# CITY OF ALBUQUERQUE

May 20, 2019

Site: Valle De Atrisco Apartments

**Re: Drainage Ordinance (14-5-2-1) Violations for Erosion and Sediment Control  
and Construction Site Waste(s)**

VALLE DE ATRISCO
EROSION & SEDIMENT CONTROL PLAN

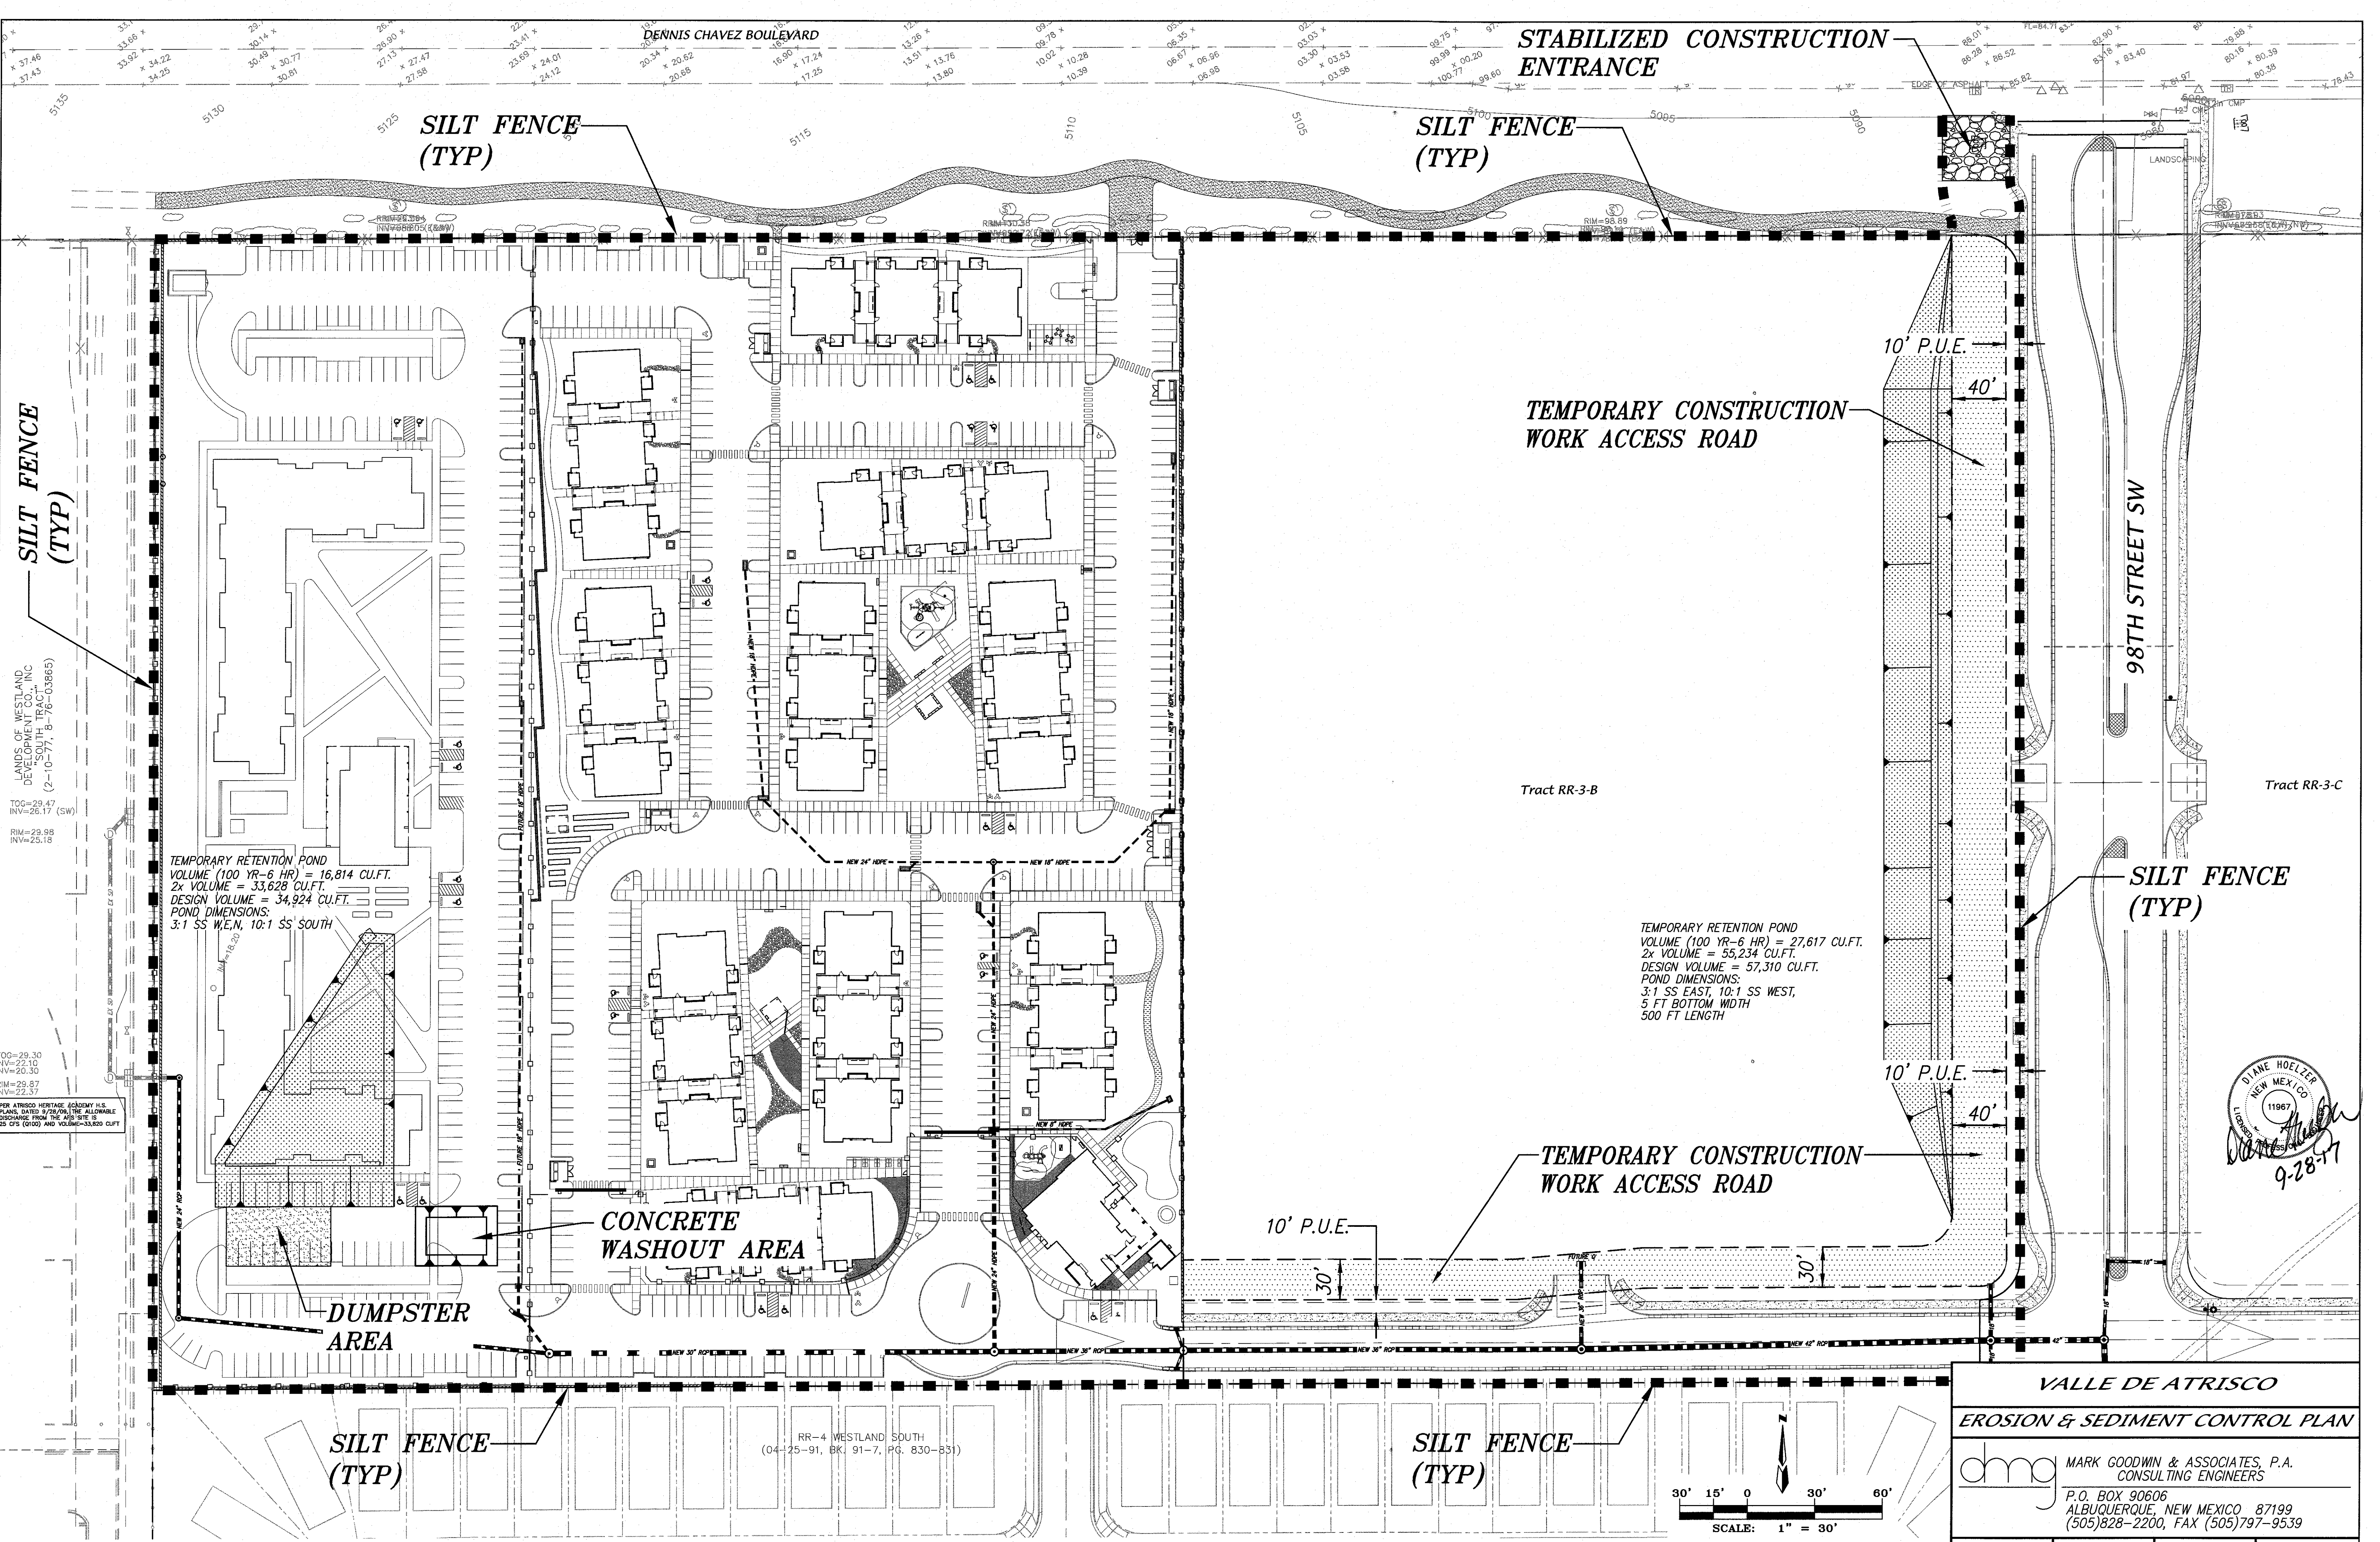
1. Soil is eroding and blowing onto adjacent property.
2. Silt fence is not maintained.
3. Construction and domestic waste not in an acceptable container.

Sediment from the construction site has blown offsite. Silt fence is full.

Silt fence requires maintenance and construction and domestic waste not in an acceptable container.

Silt fence is full.

Silt fence is torn.

Domestic waste not in an acceptable container. Silt fence is torn.

Construction waste not in an acceptable container and the silt fence is full.

1. Prevent soil from eroding by regularly watering the site or by installing erosion control blankets. Written records of watering is necessary to show that this activity is occurring, if this BMP is selected.
2. Remove sediment from the silt fence so it is less than 50% the height of the silt fence.
3. Repair/replace the silt fence where necessary.
4. Maintain the silt fence in the future so that the sediment is less than 50% the height of the silt fence and the silt fence has no gaps or tears.
5. Place and keep construction and domestic waste(s) in an acceptable container.
